City of Portland, Maine - Building or Use Permit

Permit No: 10-1071	Date Applied For: 08/30/2010	CBL: 332 C004001
-----------------------	---------------------------------	---------------------

Proposed Use: New Single Family / Build new 24' x 32' single family home with deck.	Proposed Project Description: Build new 24' x 32' single family home with deck.
--	--

PROPOSED SINGLE FAMILY HOME  
40 EASTMAN AND BEAL STREETS, PORTLAND, MAINE  
FOR: DIVERSIFIED PROPERTIES INC

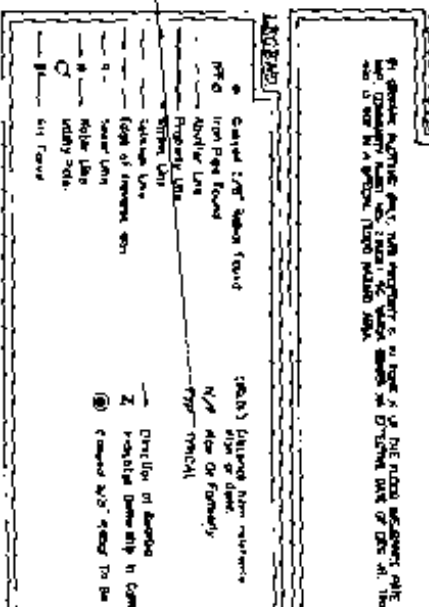
- The driveway extends 36' beyond the 25' front setback. It needs to be 38' to meet the parking requirements.
- This lot is created from two different owners. The buyer on the purchase & sales for lot 332-C-004 is Maggie May LLC & the buyer on the purchase and sales for lot 332 C-005,042 &043 is Diversified Properties.
- The left property line on the proposed lot on the survey does not match the assessor's chart.

10/21/2010-amachado: Received updated site plan from Phil which addressed site issues that Phil had. No change to the zoning requirements.
